Appeal Decision

Appeal Ref: APP/R5510/D/24/3344257

32 Bury Avenue, Ruislip, Hillingdon, HA4 7RT

- The appeal is made under section 78 of the Town and Country Planning Act 1990 (as amended) against a refusal to grant planning permission.
- The appeal is made by Mr Mark Edwards against the decision of the Council of the London Borough of Hillingdon.
- The application Ref is 23834/APP/2024/357.
- The development proposed is the extension of existing habitable roof space including 1 no. rear dormer.

Drawing Nr. 170 PL(2- 008  
Drawing Name  
PROPOSED LOFT FL PLAN

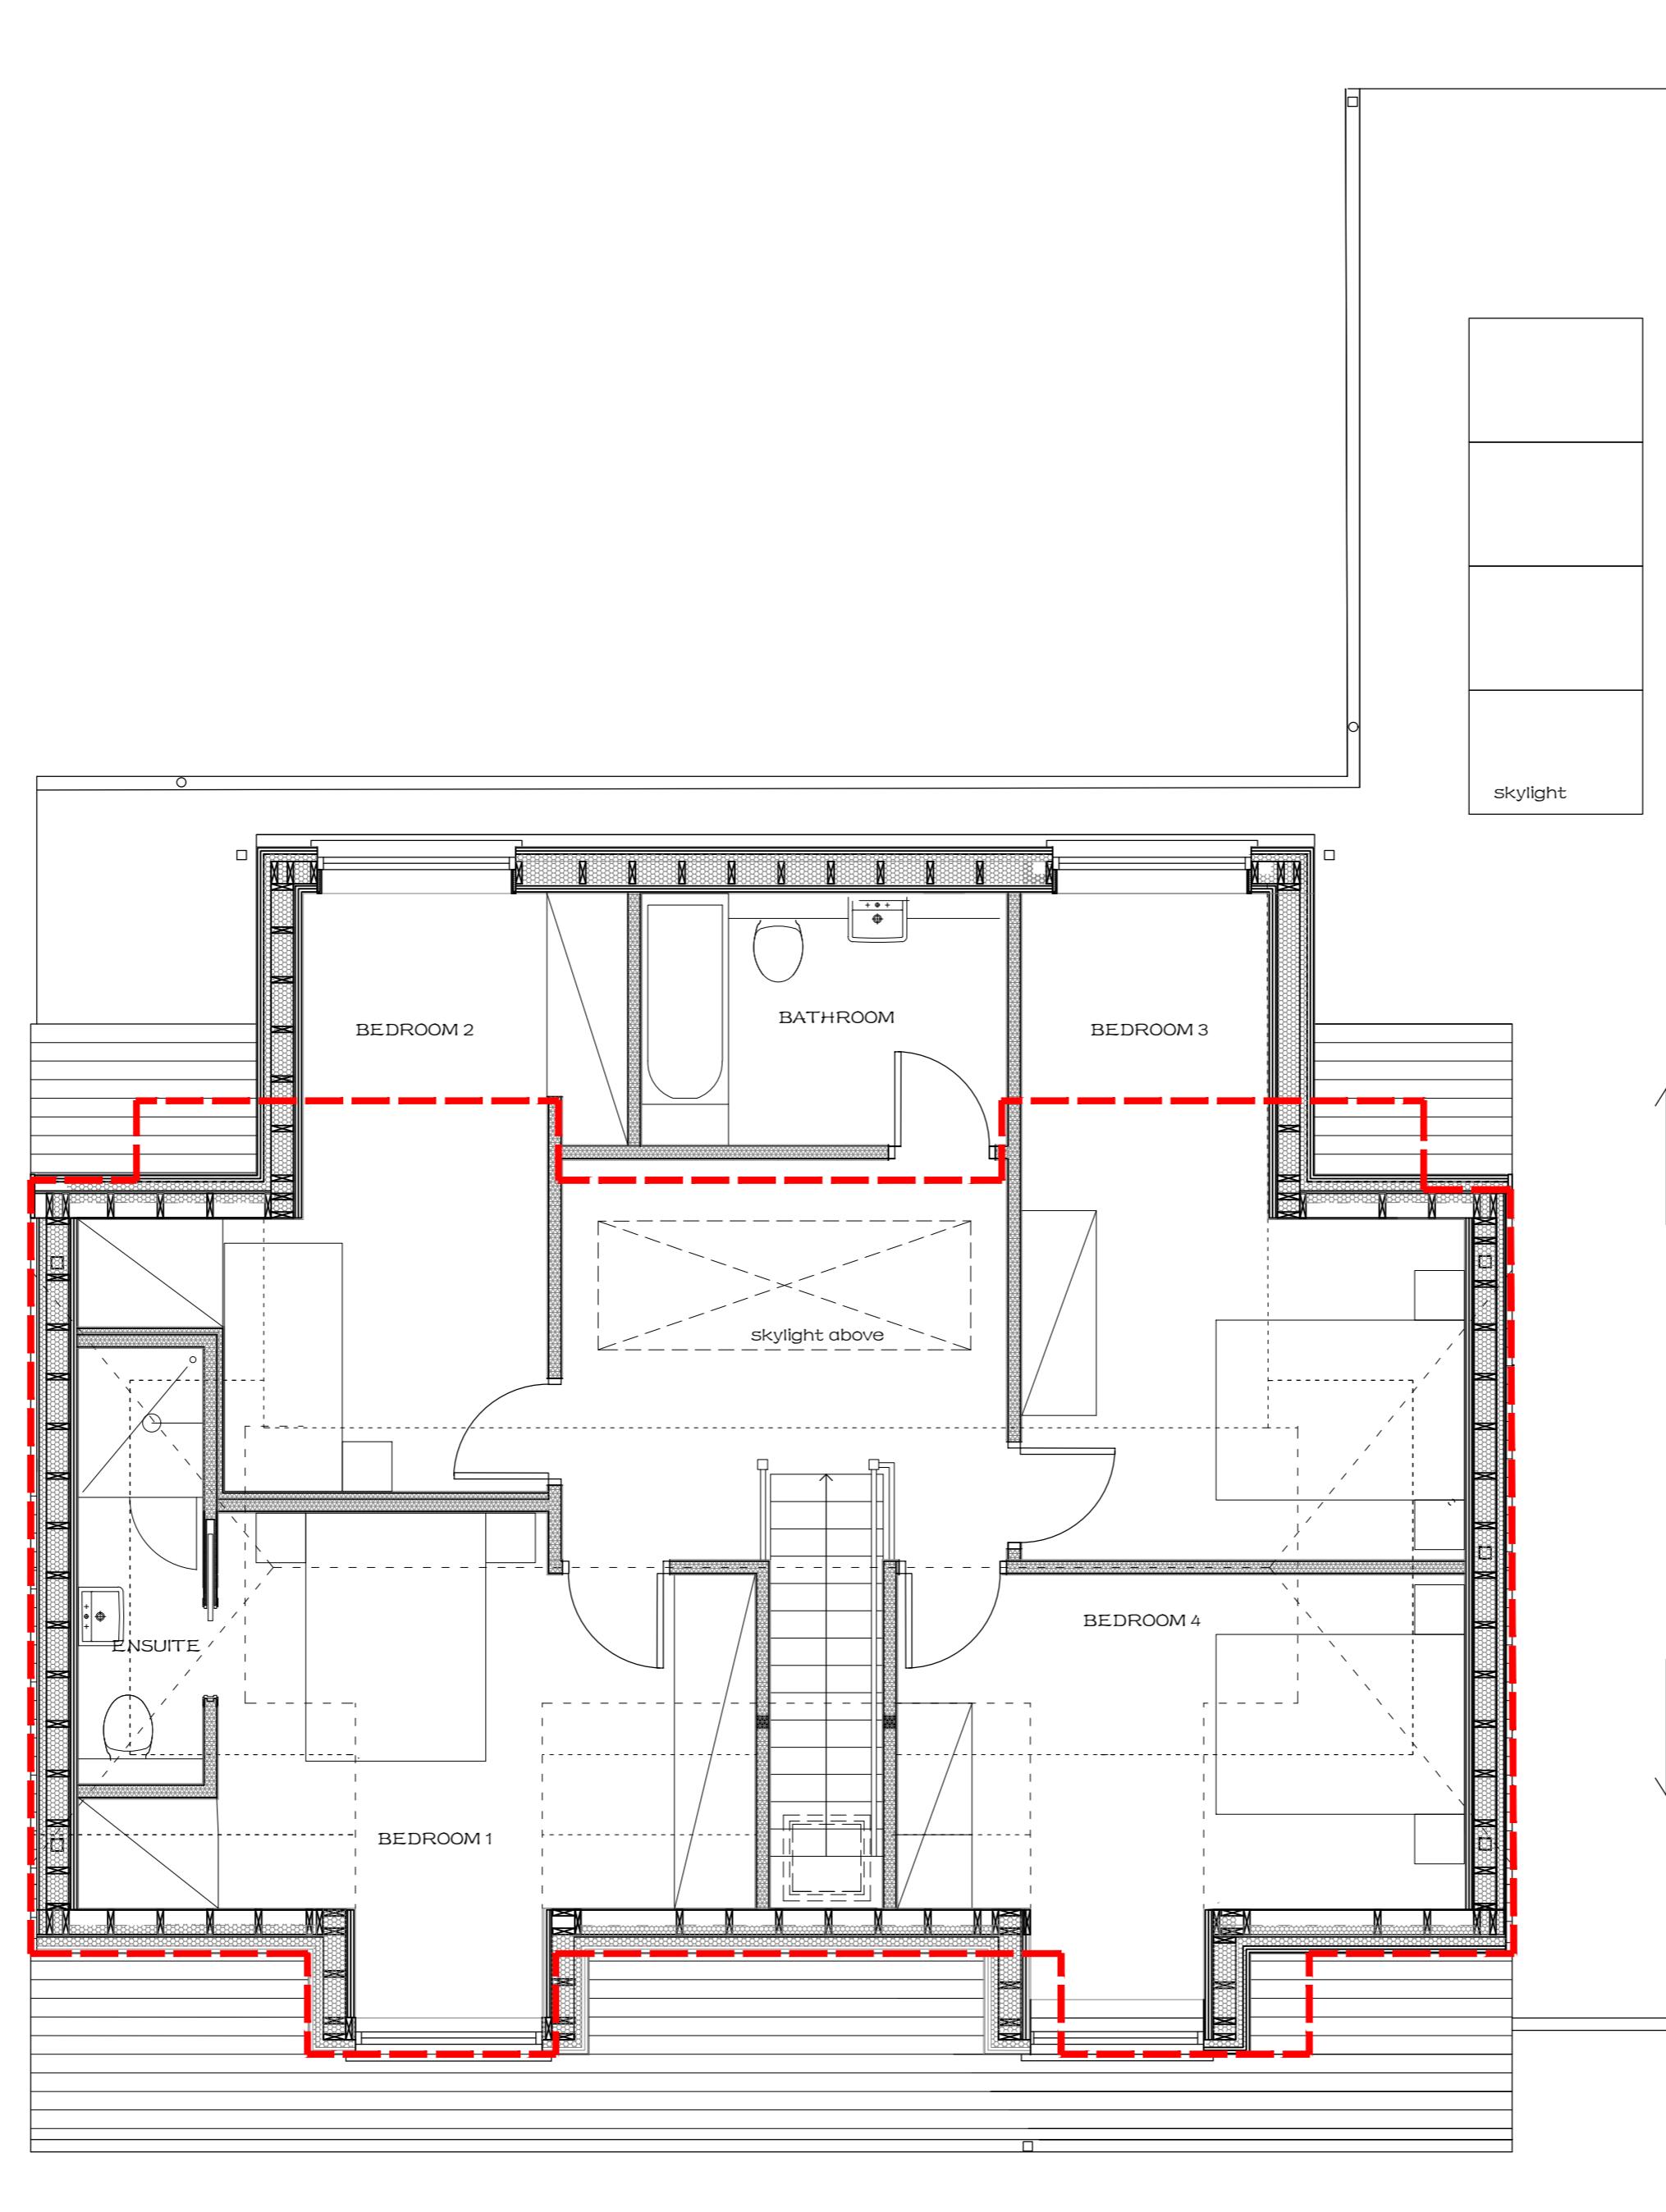
6. The rear dormer is large but is well set in from the side eaves and down from the ridge so that a sufficient element of the roof profile is retained above and to the sides. However, it extends beyond the sloped plane of the roof, over a flat roofed rear projection, ending just short of the eaves. It is therefore unduly deep and bulky. It dominates the rear elevation of the dwelling, giving it an unbalanced appearance and, owing to the corner position of the bungalow, is clearly visible from Howletts Lane from where it appears as an excessively large and incongruous addition. Overall, the rear dormer owing to its size materially detracts from the character and appearance of the original chalet bungalow.

Drawing Nr. 170 PL(2-)11
Drawing Name
PROPOSED ELEVATIONS

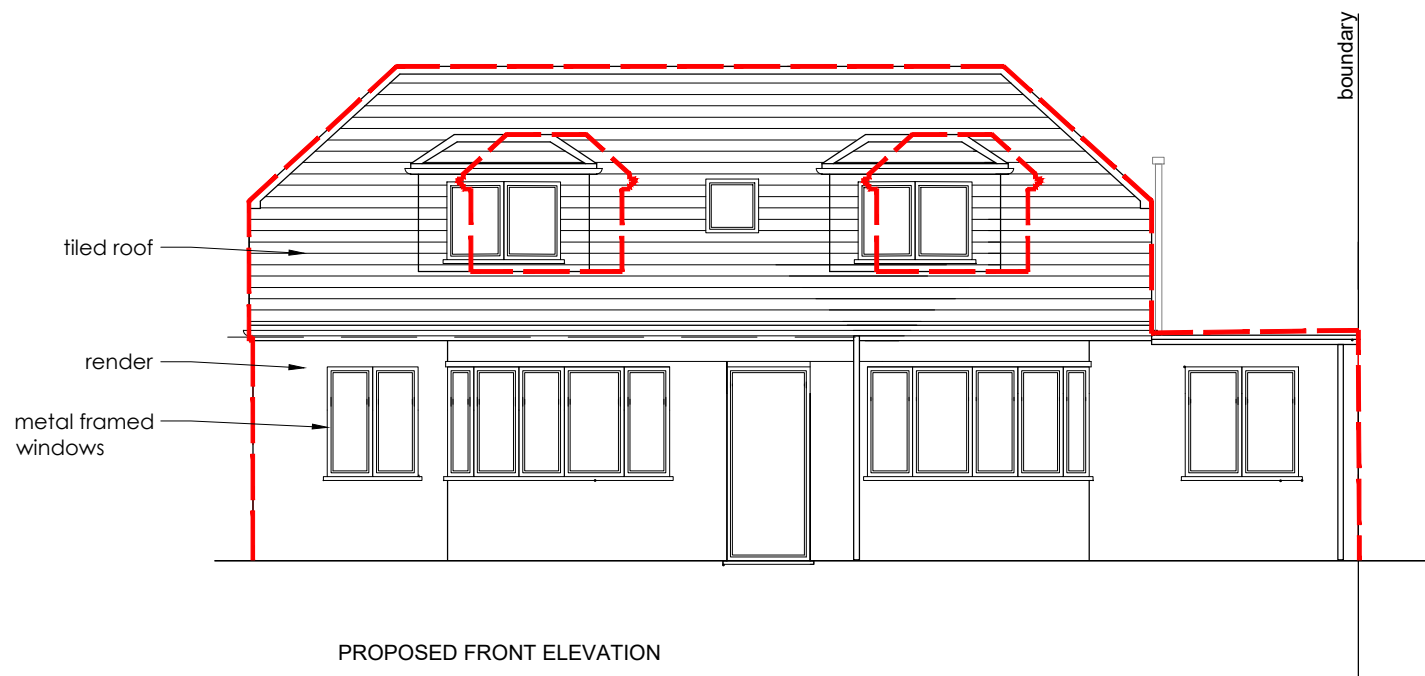
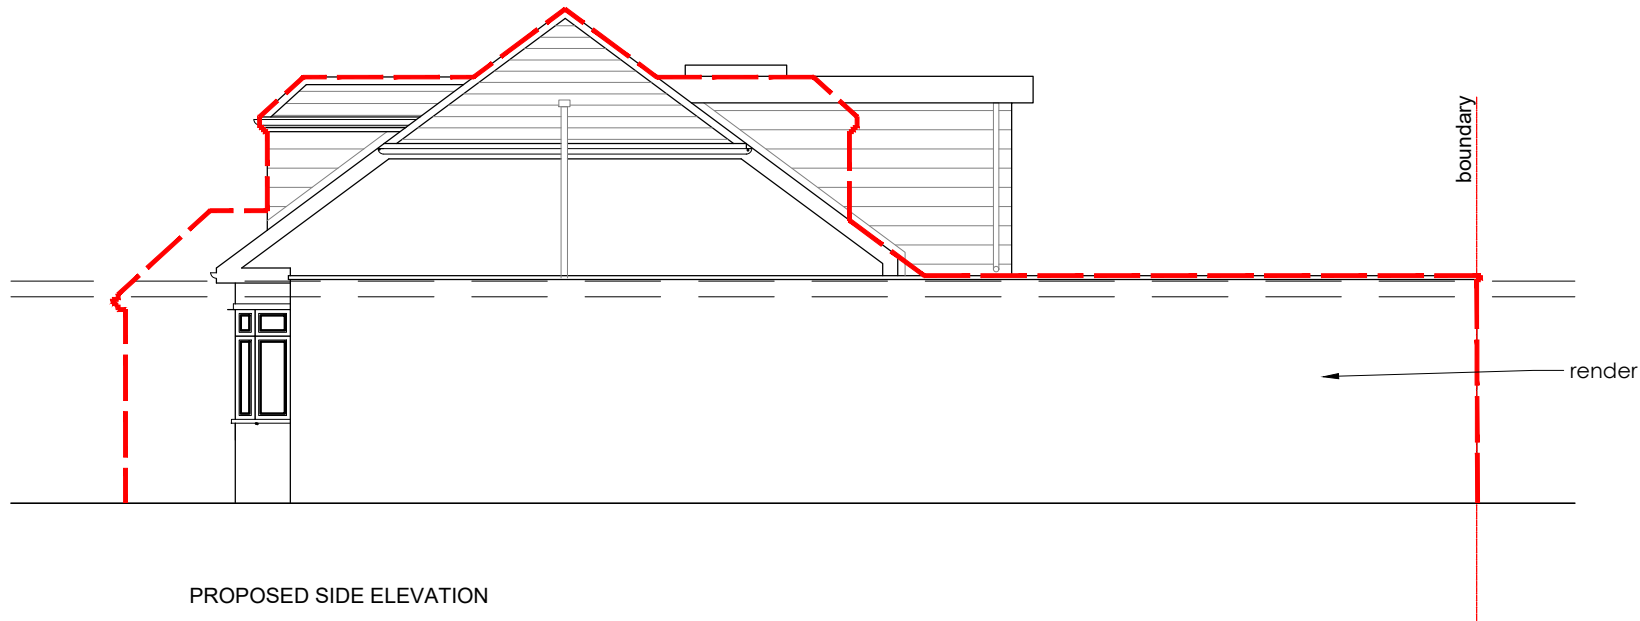
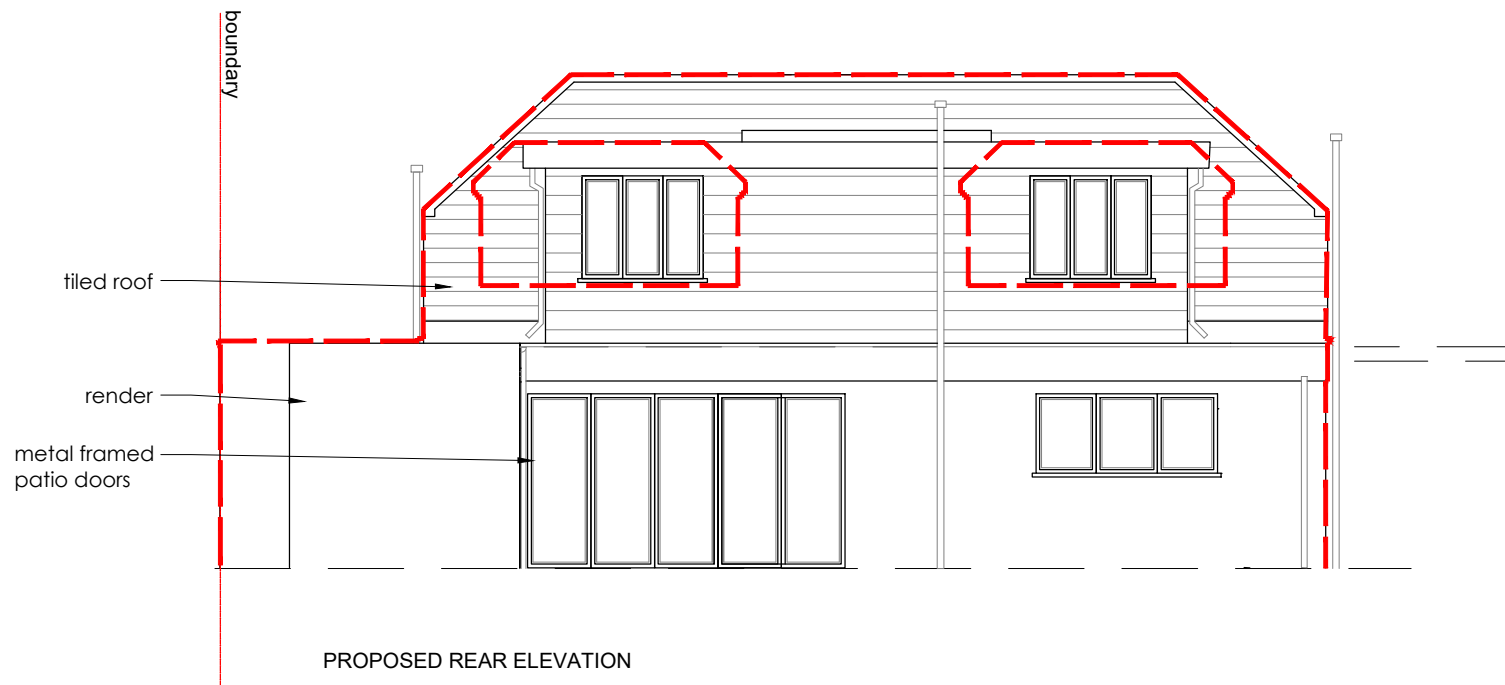
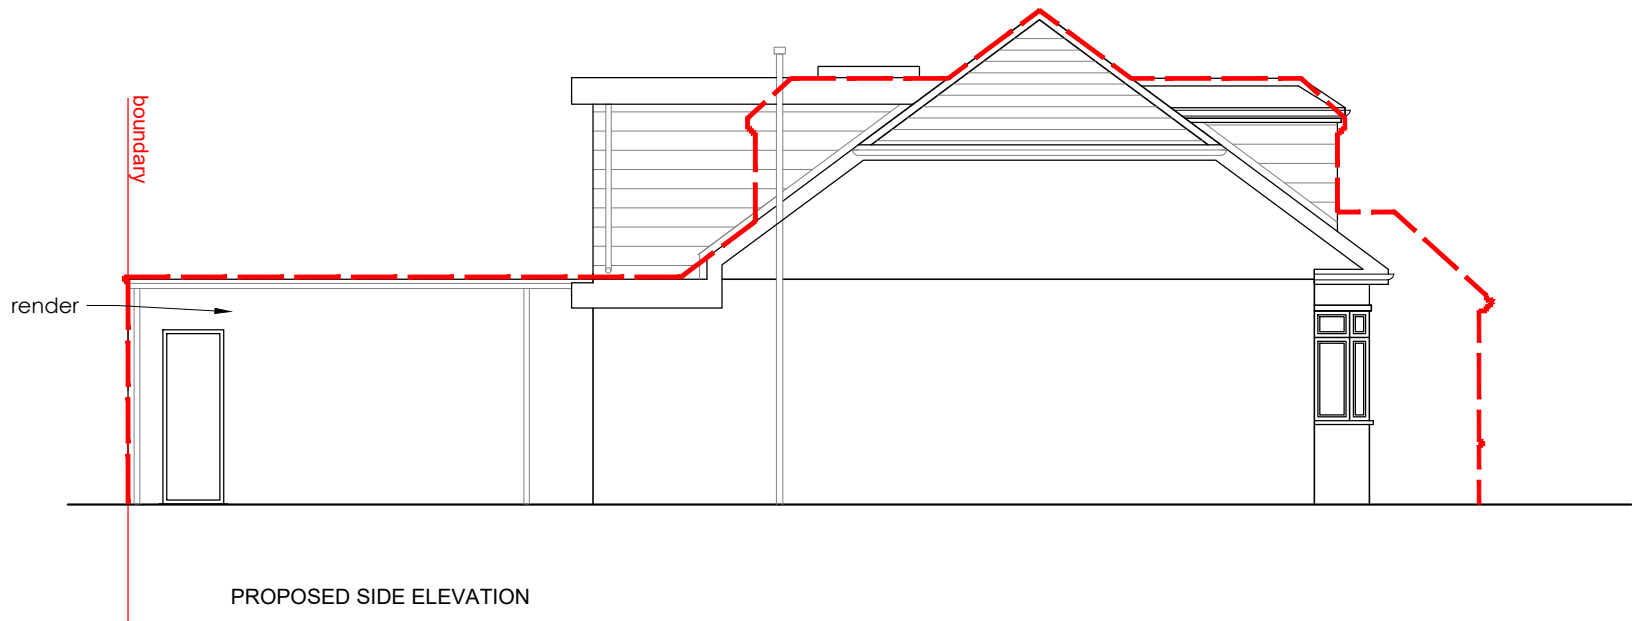
9. It is concluded on the main issue that the proposed rear dormer would, owing to its size and in particular its depth, and to its prominence in the street scene have a materially detrimental effect on the character and appearance of the host dwelling and the surrounding area. In consequence, it would conflict with Policy D4 of the London Plan, 2021, and Policies DMHB 11 and DMHD 1 of the Council's Local Plan: Part 2 – Development Management Policies, 2020. Taken together and amongst other things, these expect new development to achieve a high quality of design that is appropriate in terms of layout and scale so that it harmonises with the local context such that there is no adverse cumulative impact on the character or appearance of the wider area. In particular, roof extensions should be subservient to the scale of the existing roof and should retain a substantial element of the original roof slope above the eaves line.
